Re: BP#2016-02747 38 Washington Avenue - Plan review comments

I am handling the plan review for the revised plans for the above referenced project.

5 EXISTING STAIR SECTION  
SCALE: 1/2" = 1'-0"

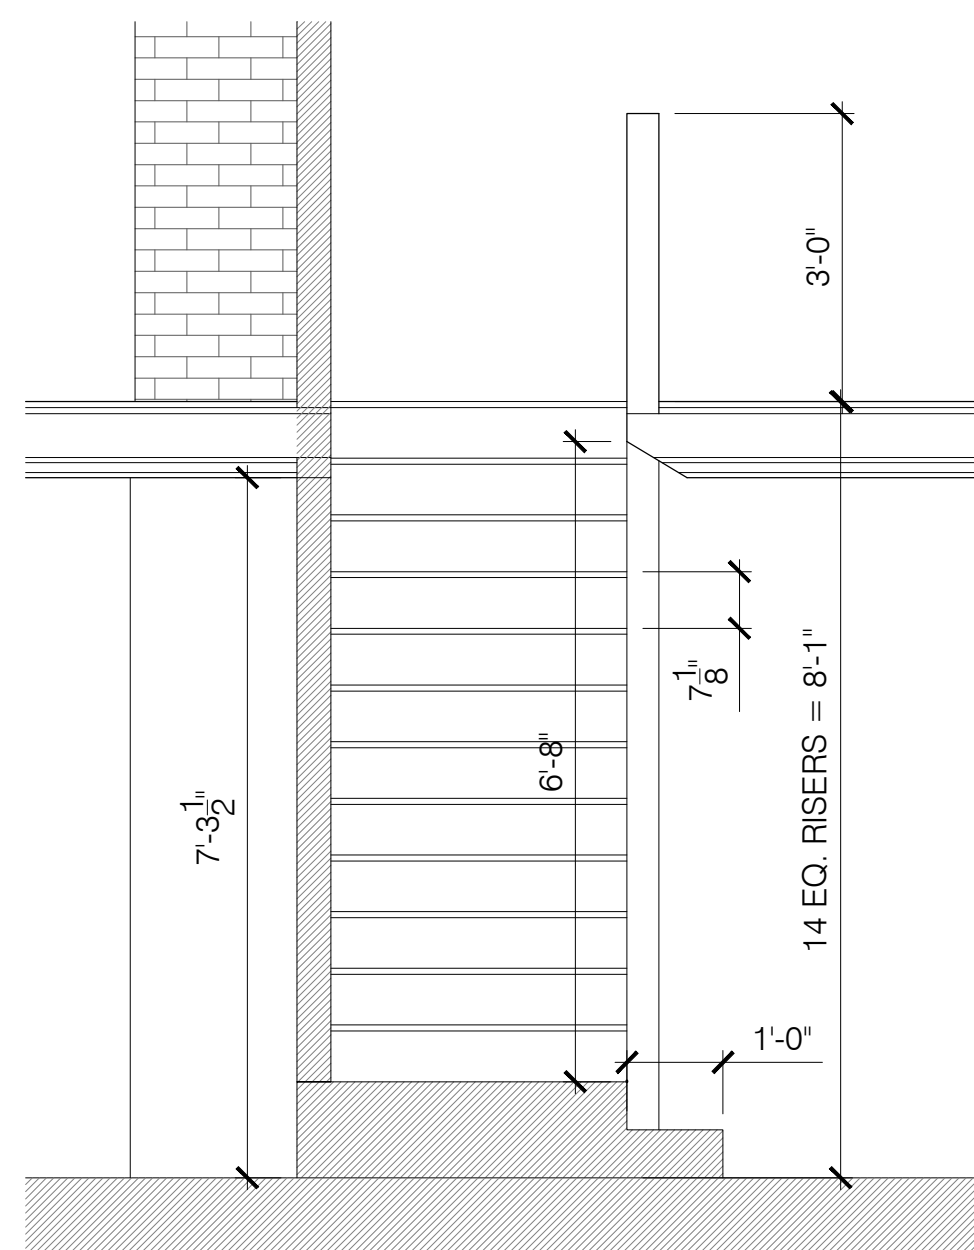
- Are the windows being replaced the same size as the existing?
- Can you label the egress windows?
- Can you clarify the door ratings between the office/storage area?
- What is the rating of the existing stair enclosure going from the first floor to the proposed office/residential entries on the second floor?

- Yes, we are replacing the existing double hung windows with casement windows using the existing rough openings, which will make them suitable for egress.
- The egress windows are labeled on the code plan, G2
- The door rating has been addressed on the revised code plan, attached.
- I have taken that stair rating to be an existing condition as previously permitted. I've attached the previous permitting drawings that says it has a 2-hour rating.
